14 September 2021
Our Reference: 2145

Planning and Listed Building Applications 21/01505/F and 21/01476/LB – Extension of existing boarding house through the reinstatement of part of the existing ruined coach house, the demolition of outbuildings, the erection of an extension and link structure (with associated alterations to Stone Hill House), insertion of internal wall, and associated works, at Stone Hill House, Stone Hill, Bloxham

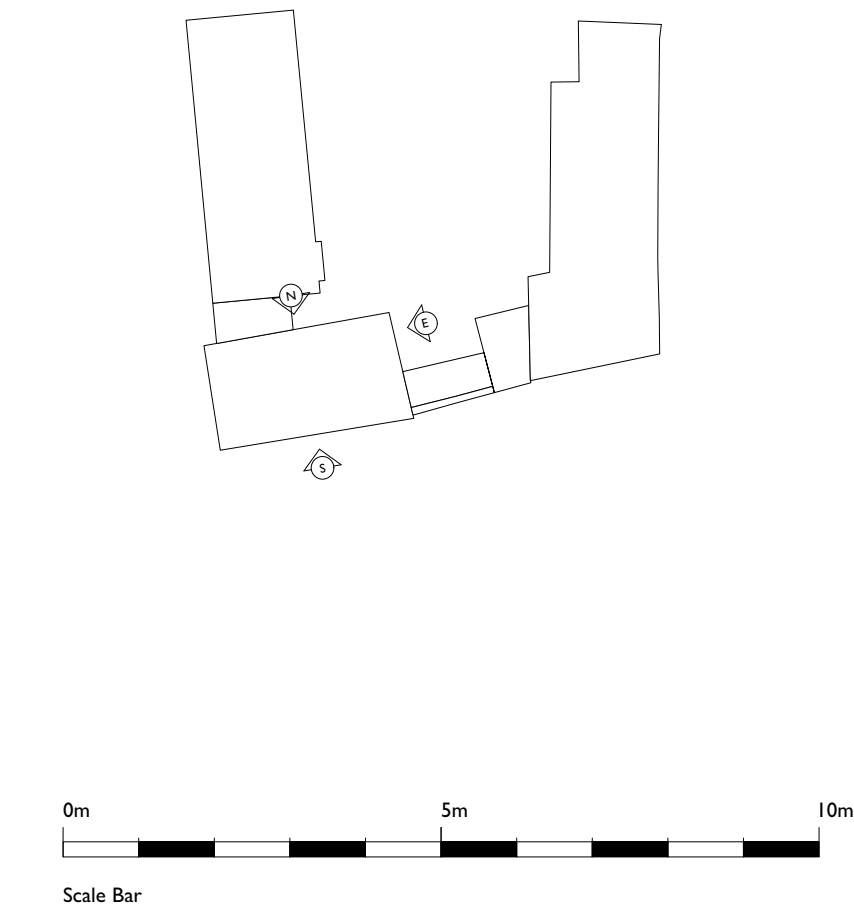
The revised drawings indicate that instead of a standing seam zinc roof covering, slate would be used for the roof covering of the reinstated coach house. This does not however reflect the photograph that HCUK included within the Heritage Addendum (a sharper version of which is attached below at Figure 1), which clearly shows the former building with a thatched hipped roof. If the building is to be reinstated, it is my clients' strong view that this should be carried out in accordance with the clear evidence of its former design and materials.

Whilst a small change has been made to the design of the access door to the Matron's Room from Stone Hill, the revised drawings do not resolve the limited separation that will result between the restored Coach House and Ashwell Cottage. Therefore the impact that the proposed development will have upon impact that the proposed development would have upon Ashwell Cottage in terms of loss of privacy and outlook and by overshadowing, as explained in detail in my previous letter, is not resolved and the development remains to be contrary to Neighbourhood Plan Policy BL9 which seeks to ensure that the living conditions of neighbouring residents are not materially harmed and Local Plan Policy ESD15 which requires new development to consider matters of residential amenity including privacy.

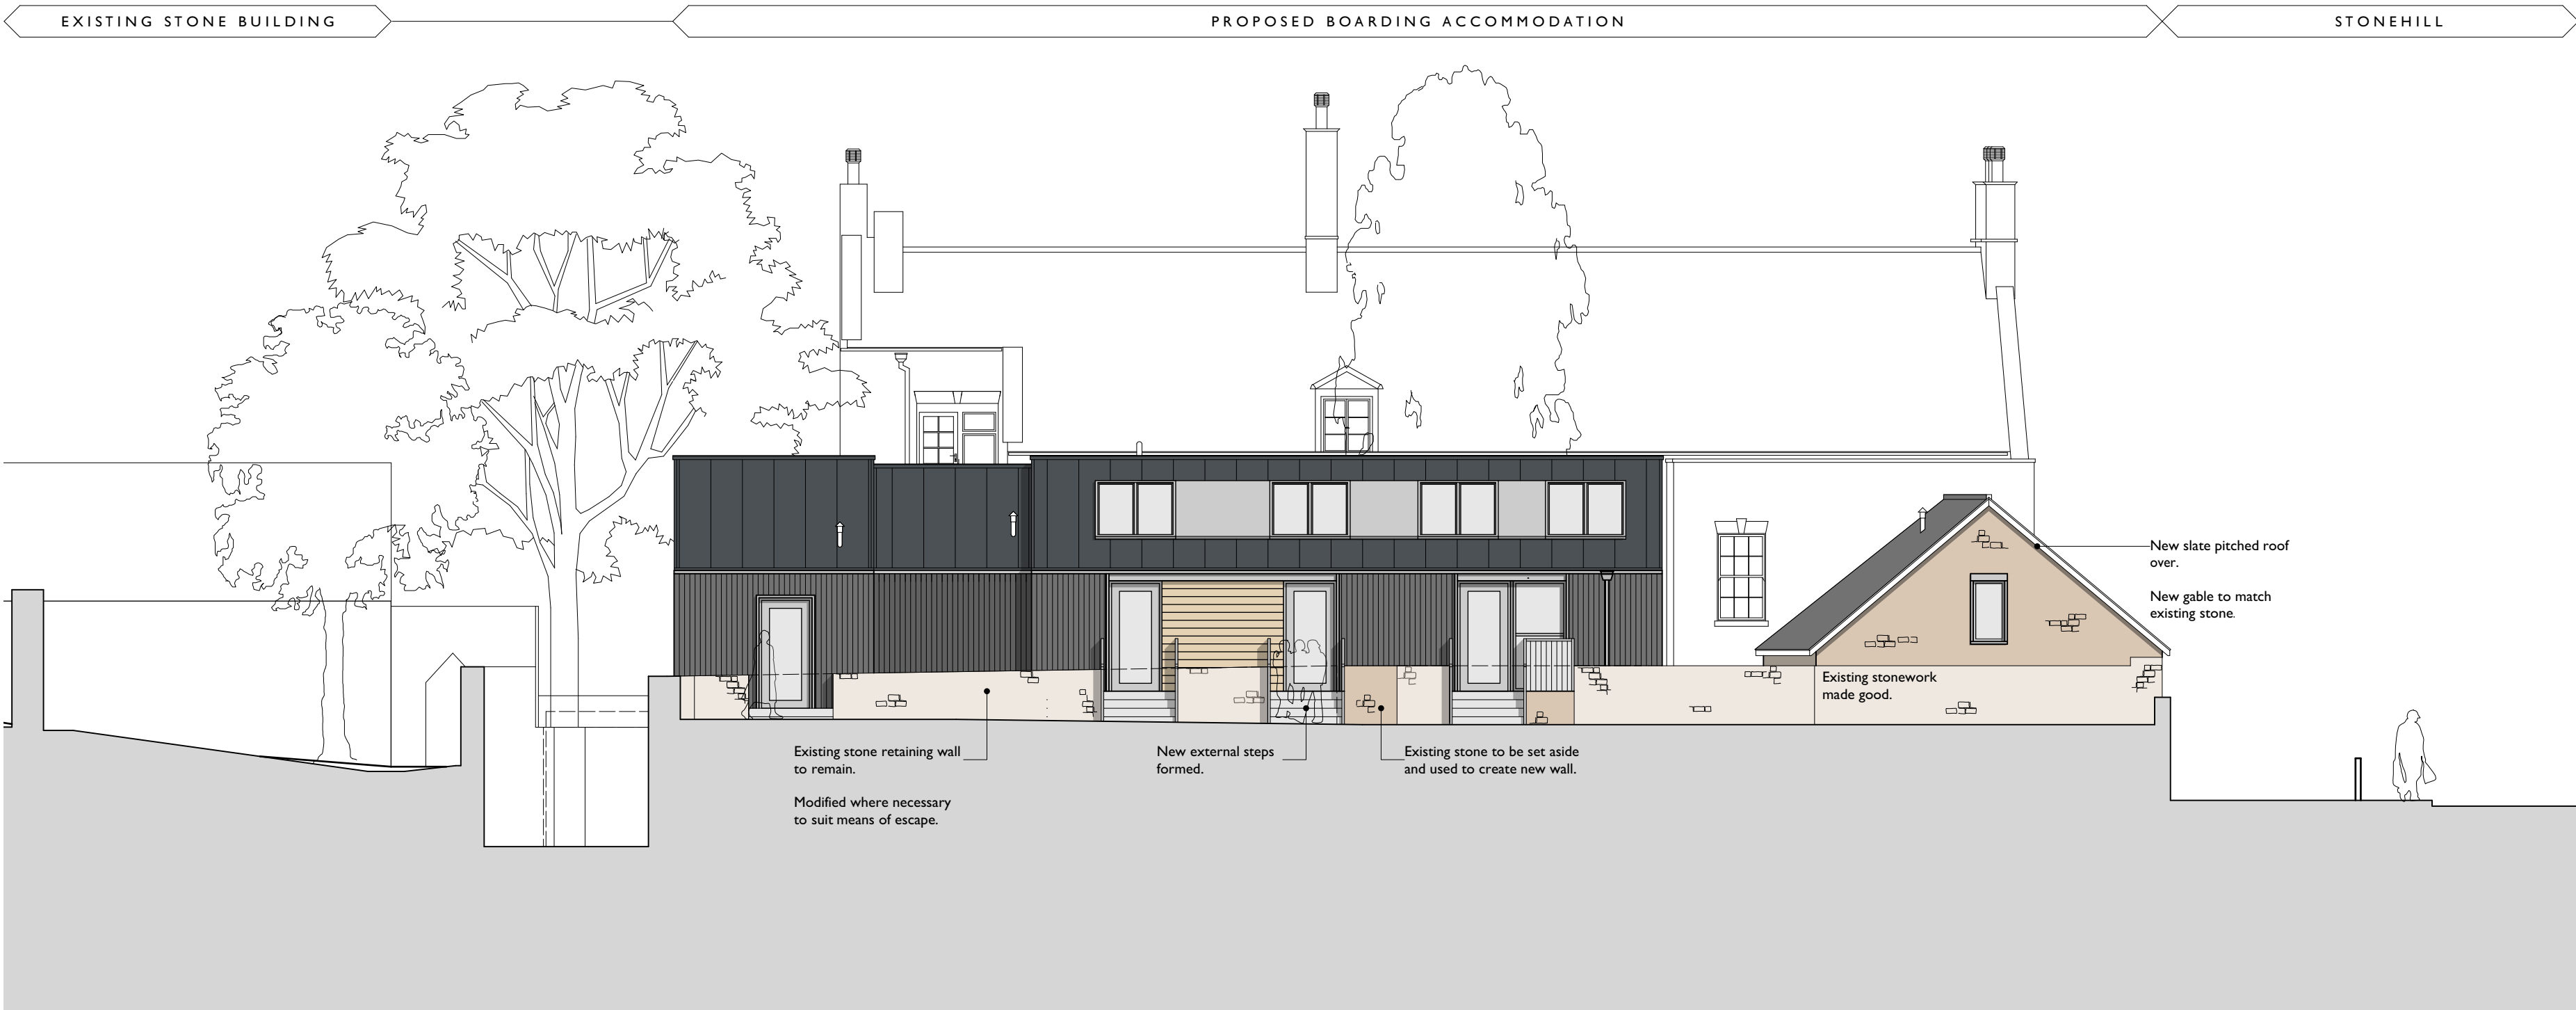
The revised drawings show that the common room and dormitory block would continue to result in a loss of the historic boundary wall between Stone Hill House and Old Park Farm. It is James Edgar's professional opinion that this part of the revised proposal would have the same harmful impact as referred to above on the historic legibility between Stone Hill House and its ancillary areas and Old Park Farm. Again, good conservation practice would be to retain the separation between the individual elements of the historic environment. Furthermore, the large footprint and scale of the new building would continue to compete unacceptably with the scale of the host house. The impact of this part of the proposal remains the same as set out in my previous letter, which is contrary to the relevant Development Plan policies and guidance contained within both the Bloxham Conservation Area Appraisal 2007 and, in particular the Management Plan contained within the draft Bloxham Conservation Area Appraisal (2020).

Although the amended drawings indicate that the ridge of the common room and dormitory block would be reduced, the fact remains that its footprint would still be as long and as wide as Stone Hill House, as identified in James Edgar's report, therefore still competing with its scale and representing harmful overdevelopment of the site in direct conflict with Local Plan Policy ESD 15 which requires all new development to be designed to improve the quality and appearance of an area and respect the form, scale and mass of buildings, Neighbourhood Plan Policy BL11 which requires all development to relate in scale, massing and layout to neighbouring properties and the Council's support for new buildings which are sympathetic to the intrinsic character of the area in terms of scale, design and materials as set out

The revised drawings do nothing to address my clients' strong objections to the materials and design of the proposed development. The complex mix of materials remains, together with a wide range of fenestration styles, including within the historic wall which faces Stone Hill, that would appear highly discordant and which would have a damaging, urbanising affect within this sensitive part of the Bloxham Conservation Area, contrary to Local Plan Policy ESD 15 which requires all new development to be designed to improve the quality and appearance of an area and to reflect or, in a contemporary design response, re-interpret local distinctiveness, including elements of construction, elevational detailing, windows and doors, building and surfacing materials, mass, scale and colour palette. The revised scheme is also contrary to Neighbourhood Plan Policy BL11 which sets out that the design and materials chosen should preserve or enhance rural heritage, should be in keeping with local distinctiveness and characteristics of the historic form of the village, make a positive contribution to the character of Bloxham and its rural feel, and use materials in keeping with the distinctive character of our local brick or ironstone. Nor do the revised drawings recognise the Council's support for new buildings which are sympathetic to the intrinsic character of the area in terms of scale, design and materials as set out in the adopted Bloxham Conservation Area Appraisal (2007).
